Modification 2 of Novus Build-to-Rent, Parramatta

State Significant Development Modification Assessment Report (SSD-34919690-Mod-2)

July 2025

Section B | Harris St Setback

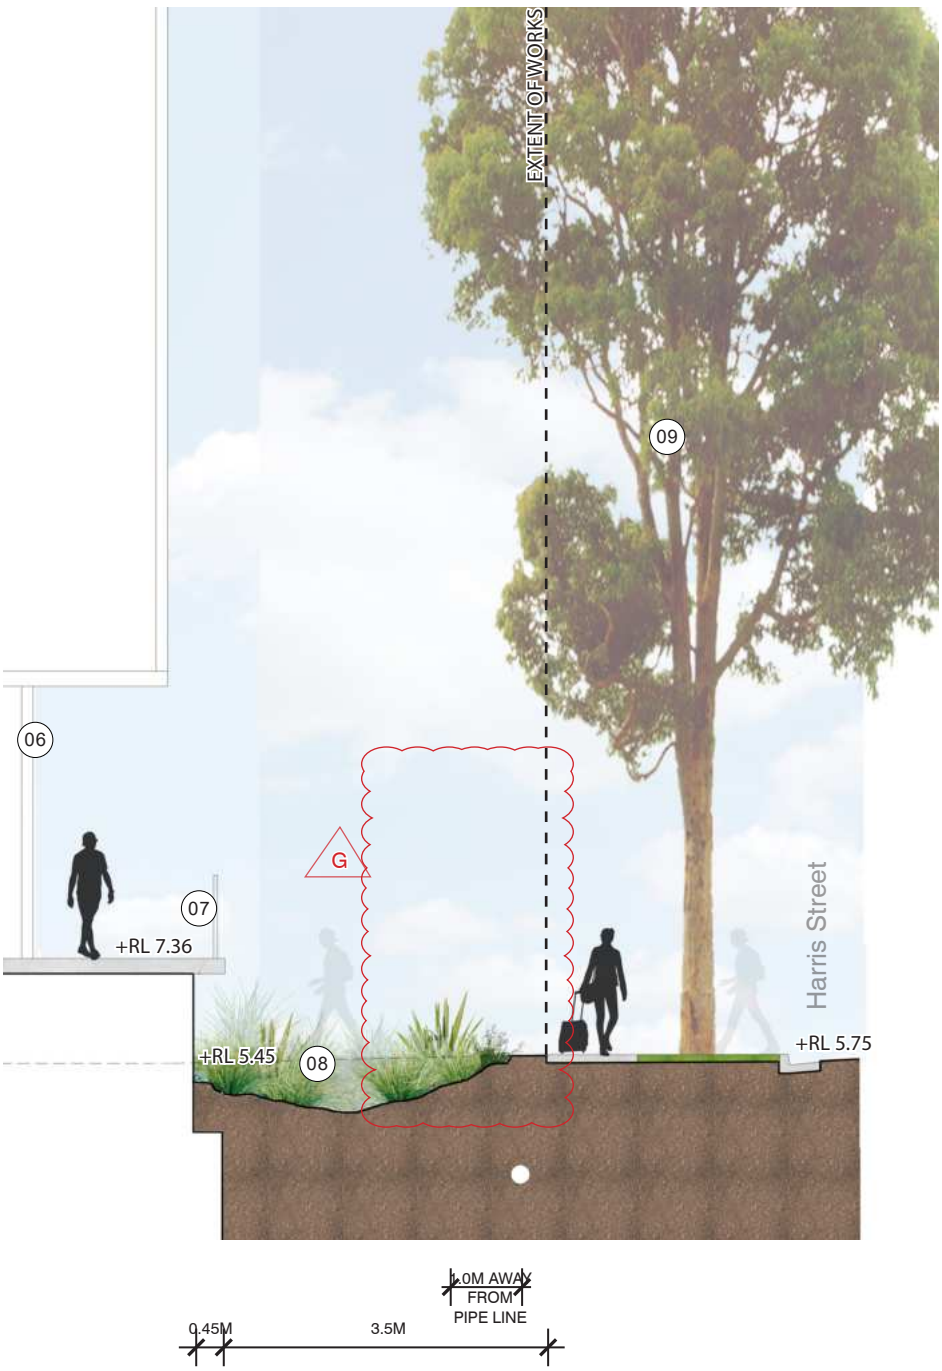
Council maintains their comments with regards to dwelling mix and urban design. Council additionally notes that the location of Watergum and Blueberry Ash trees conflicts with the construction and built form.

The Department requested the Applicant provide further information to address the location of Water Gum and Blueberry Ash trees to respond to Council's comments on the RtS.

- the two Water Gum trees have been removed from the Harris Street frontage to provide sufficient clearances to underground infrastructure and the building line
- the Blueberry Ash tree has been relocated outside the podium line by adjusting the alignment of the pedestrian stepping stone path at the ground floor level.
